December 20, 2019

File: PG4777-LET.03R

Subject: **Geotechnical Grading Plan and Site Servicing Plan Review
Proposed Commercial Development
6075 Bank Street
Ottawa (Greely)**

1. ARK Drawing No. GP – Grading Plan, Revision 4, dated December 18, 2019.
2. ARK Drawing No. SS – Site Servicing Plan, Revision 4, dated December 18, 2019.

GRADING PLAN

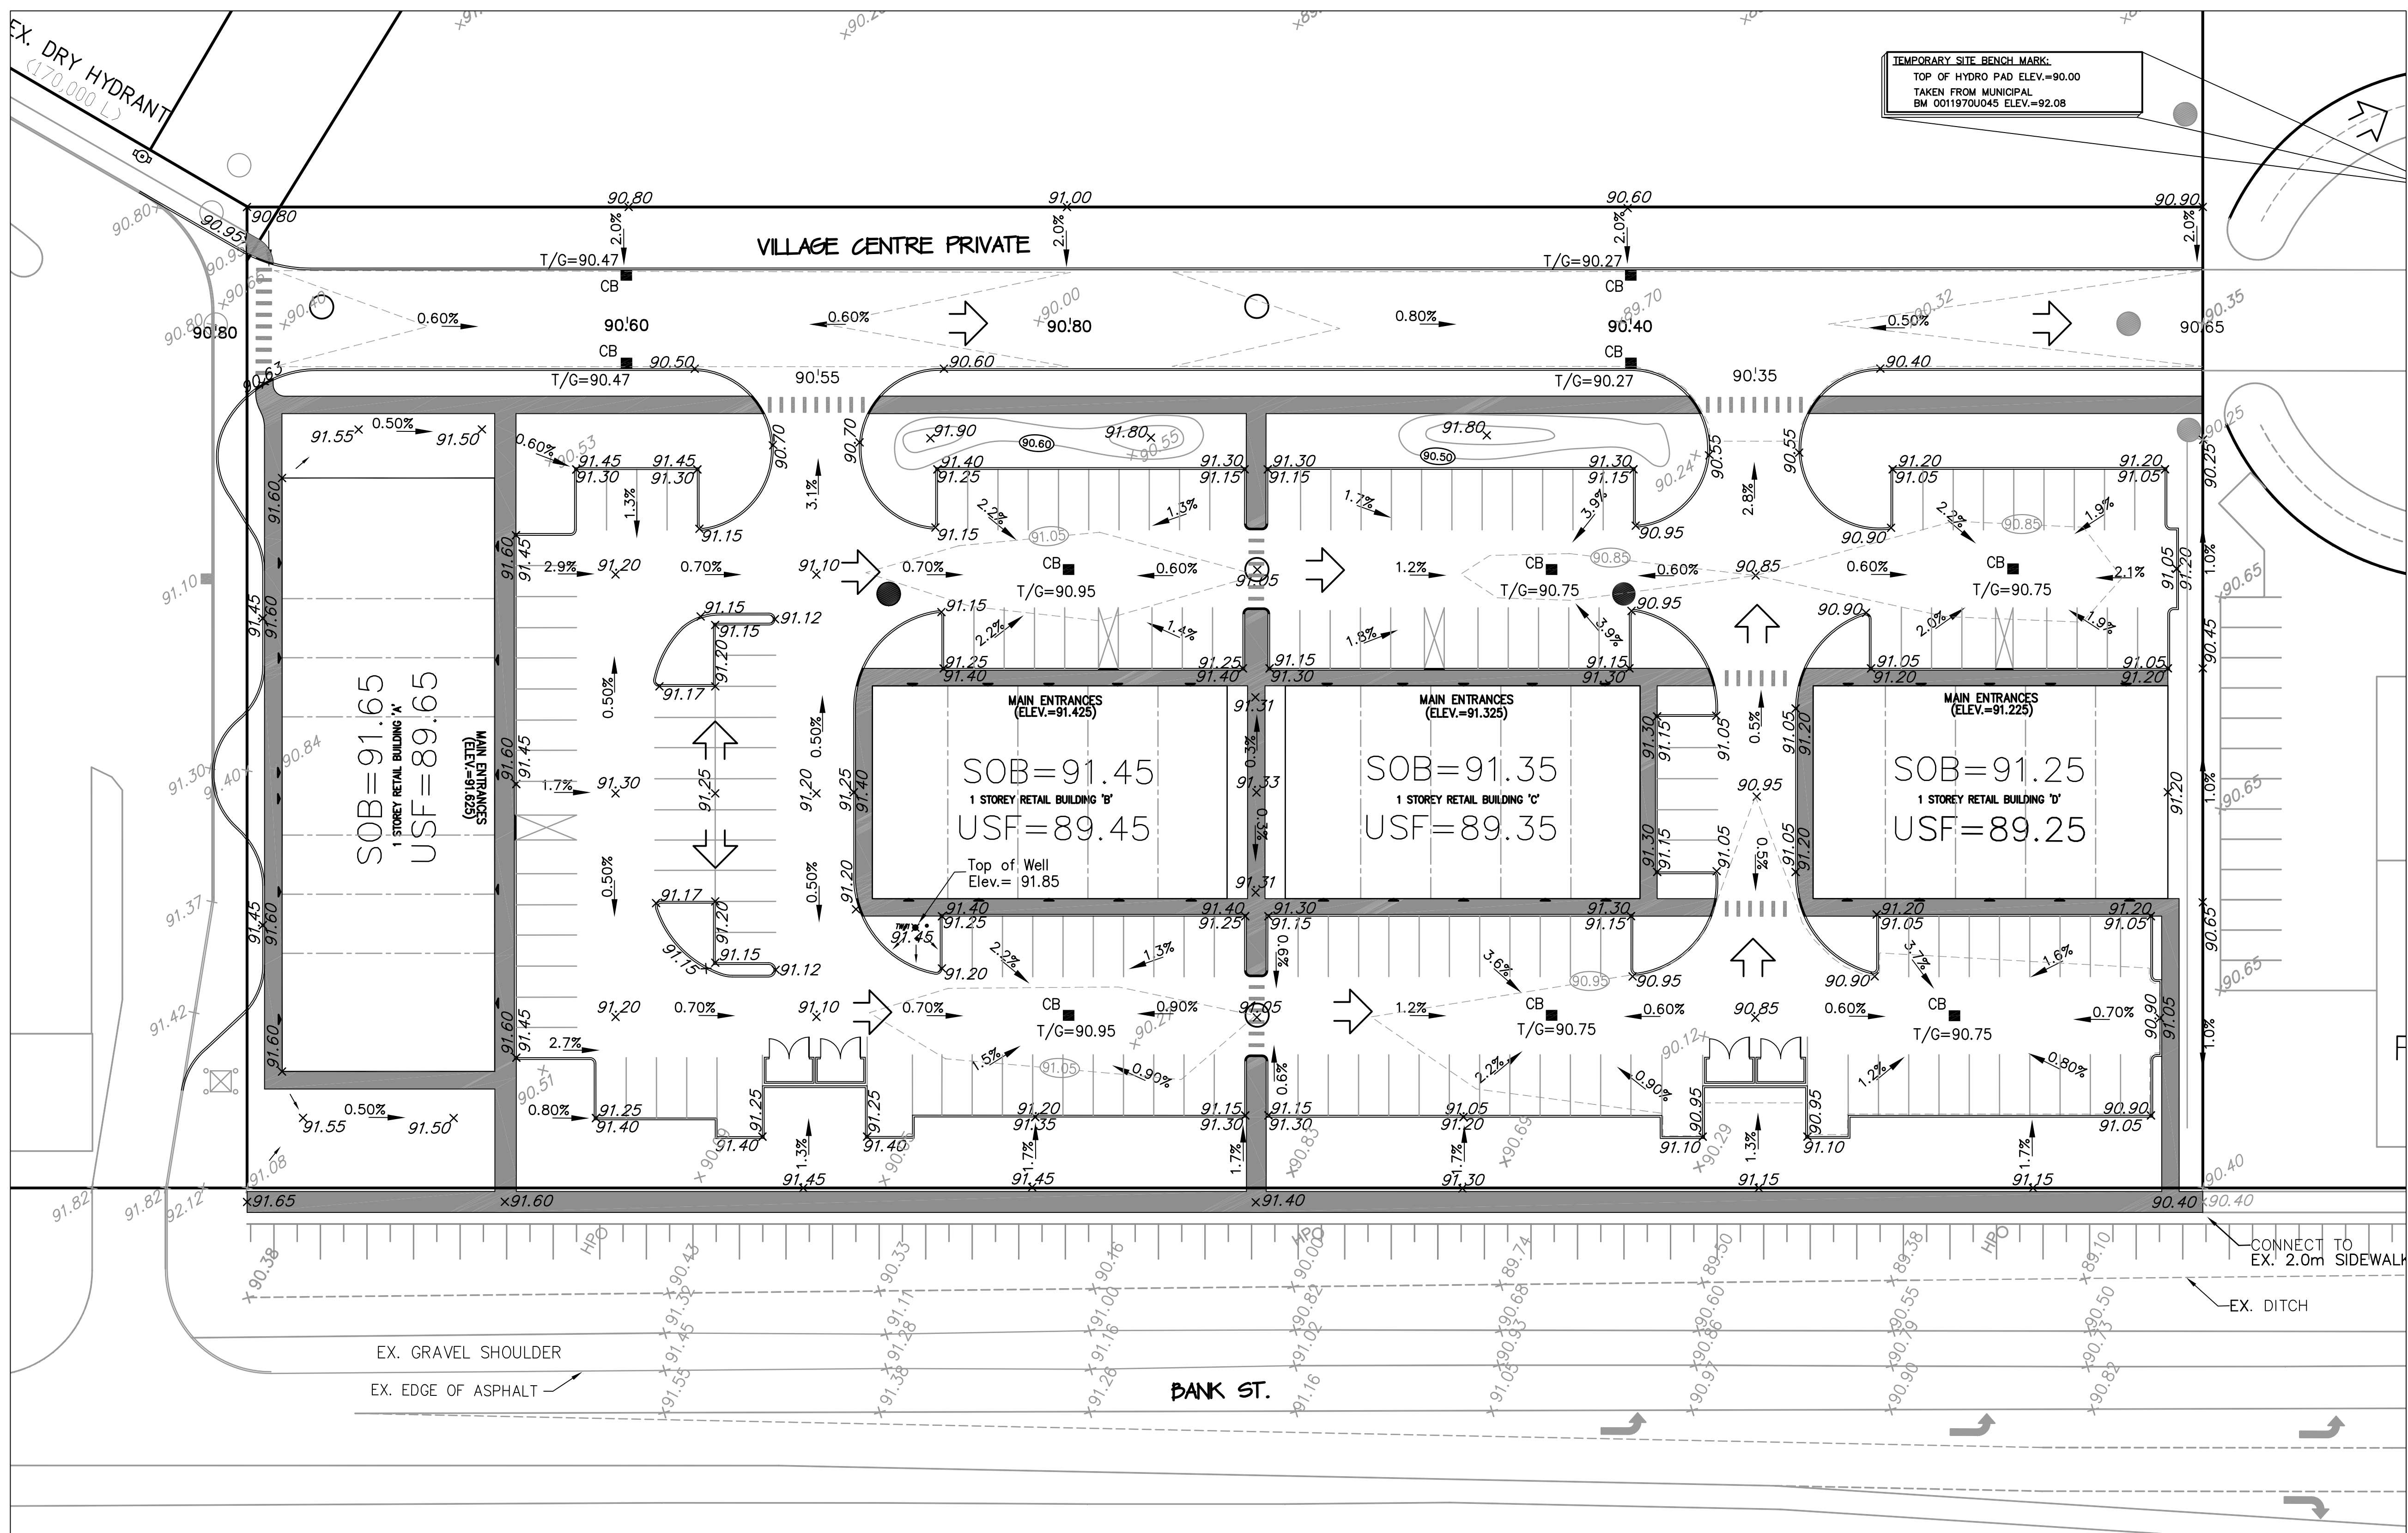
Based on the present ground elevations, the finished floor levels of the proposed buildings will represent a grade raise of between 1.0 and 1.4 m. There are existing fill deposits that extend to depths of up to 1.52 m below the existing ground surface. Based on the interpreted native soil surface levels, the grade raise is 1.2 to 2.7 m. These grade raises are acceptable from a geotechnical perspective for the proposed commercial buildings.

The Grading Plan and the Site Servicing Plan - Revision 4, as referenced above, are acceptable from a geotechnical perspective for the proposed commercial building development.

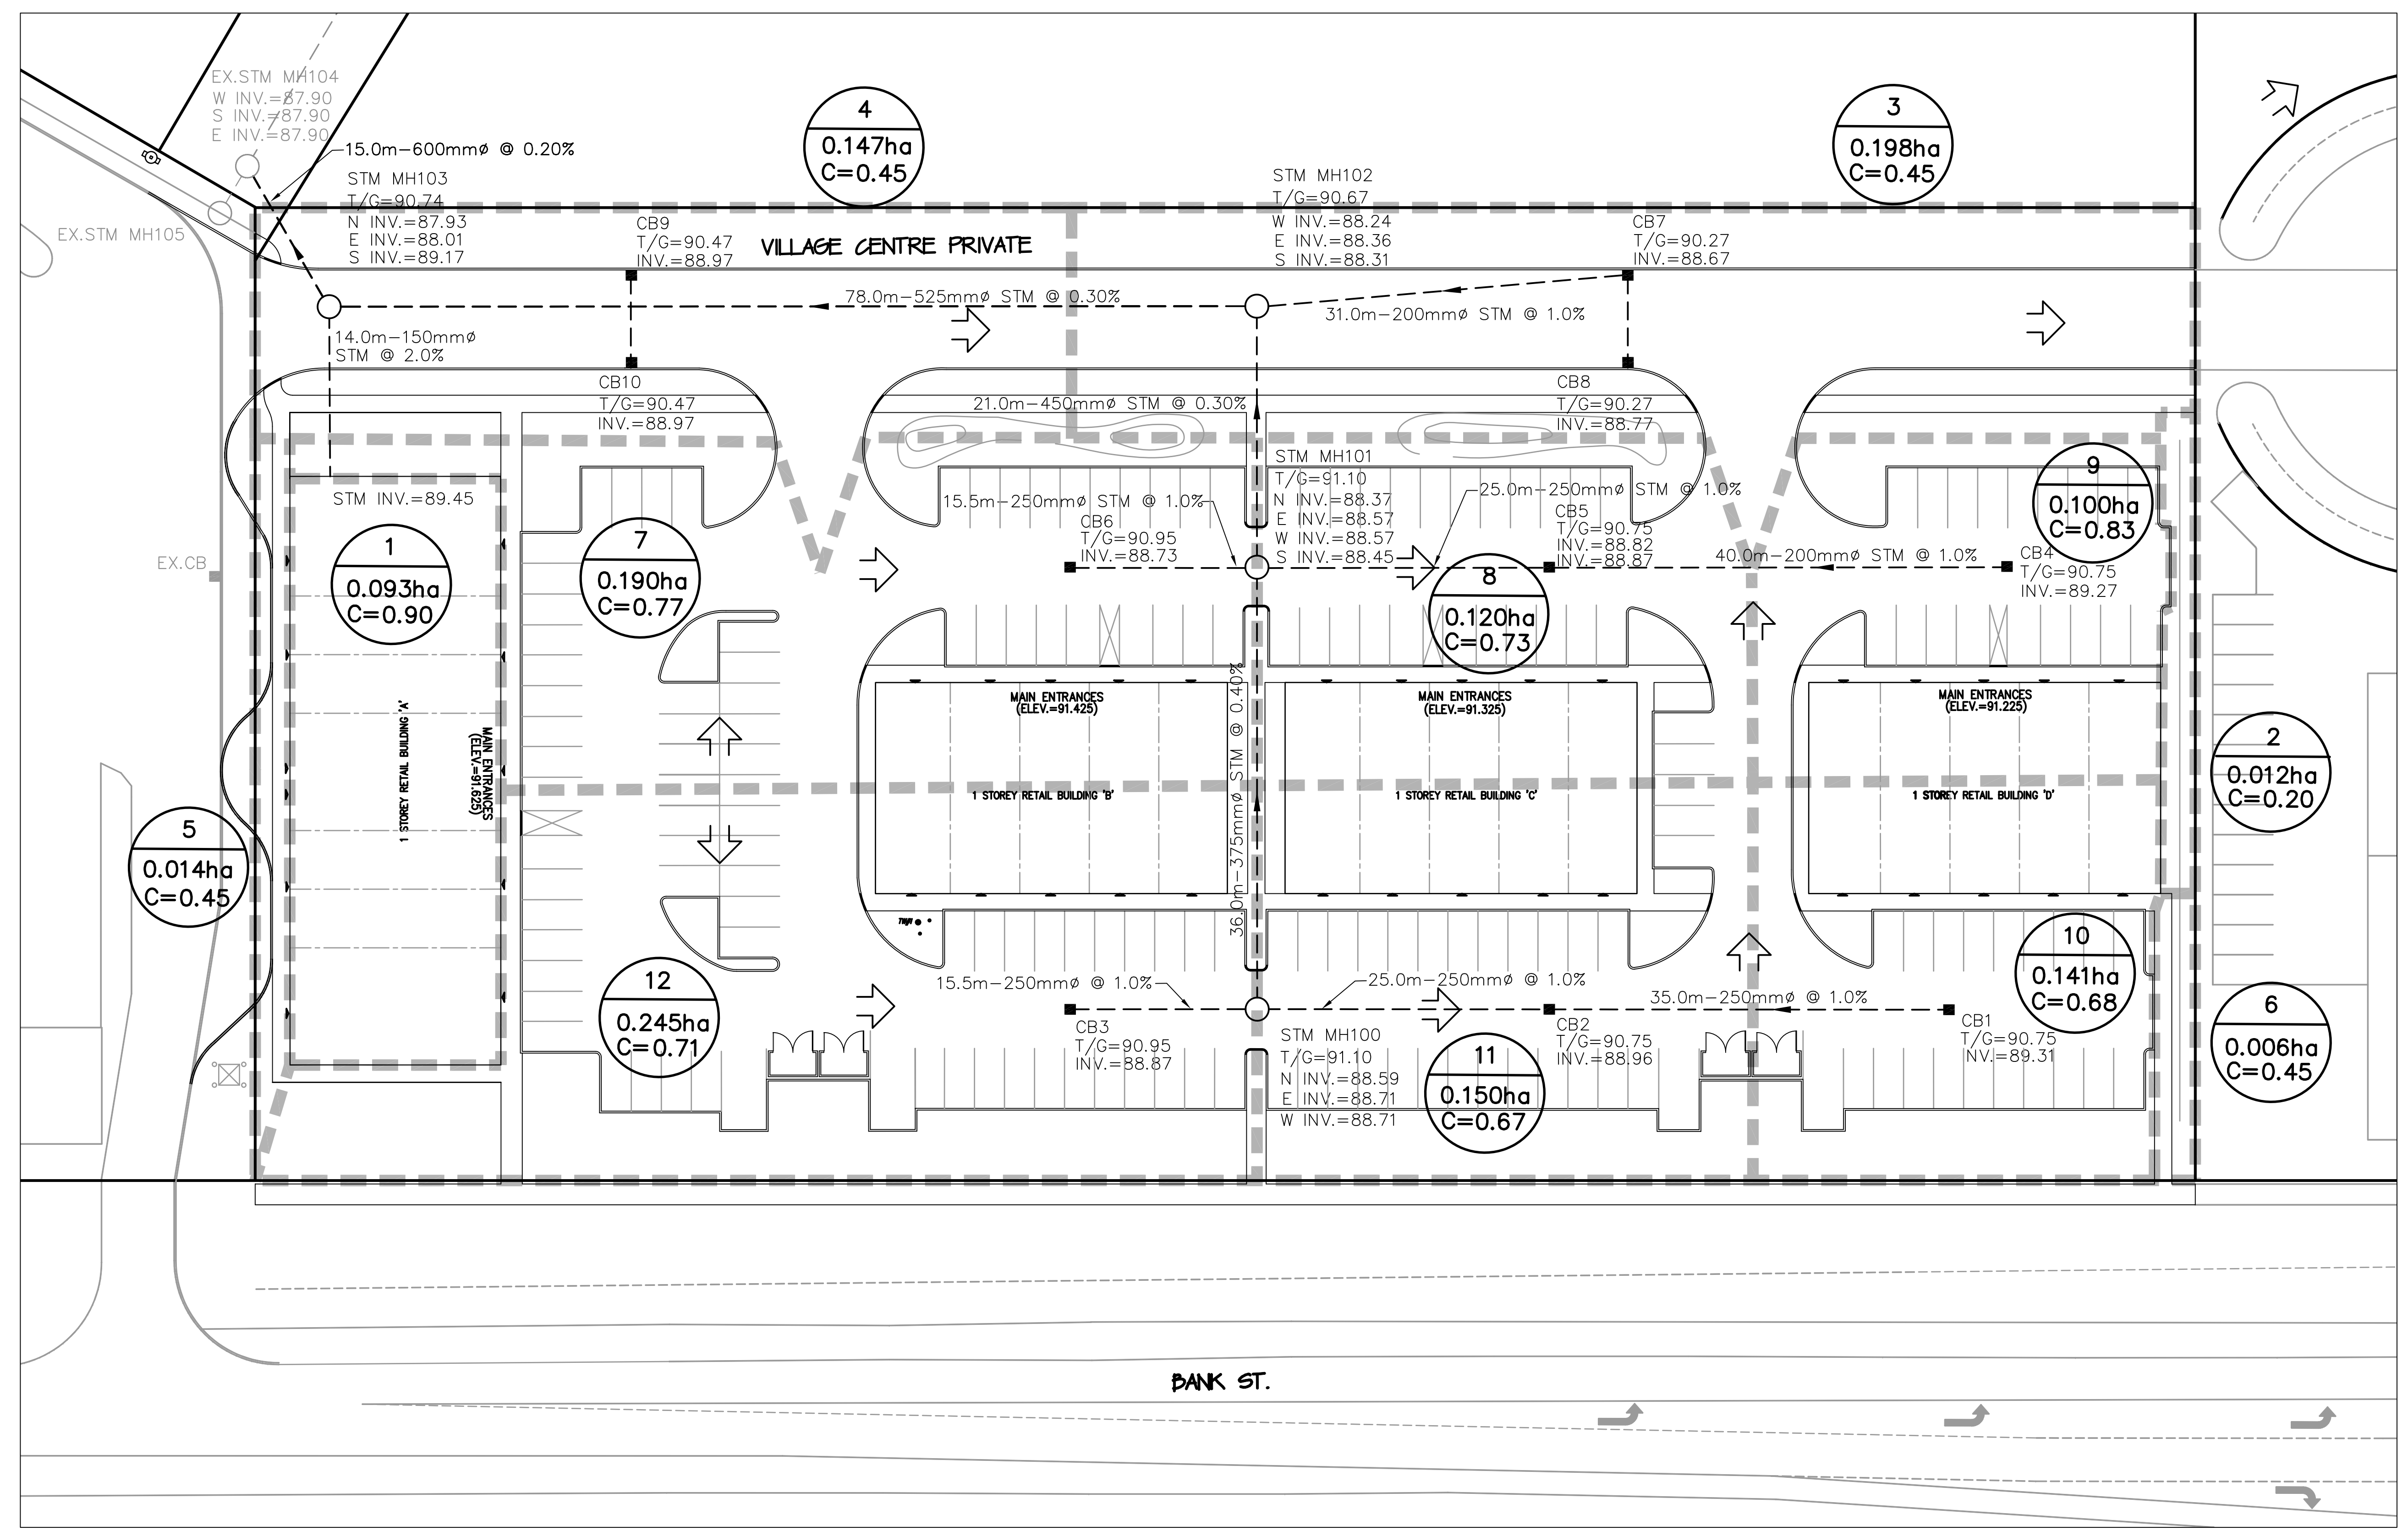
The development will be served by municipal services. The water service has obvert levels of between 89.1 and 88.8 m. The sanitary sewers have invert levels of between 89.5 and 89.2 m at the building connections and 88.54 m at the street connection. The storm sewers have invert levels of between 88.6 and 87.9 m.

The groundwater levels are, therefore expected to be at or below the invert levels of the proposed servicing for the development. As such, the installation of services for the development will not be adversely influenced by groundwater and groundwater control should be routinely handled by pumping from temporary sumps in the trench excavations.
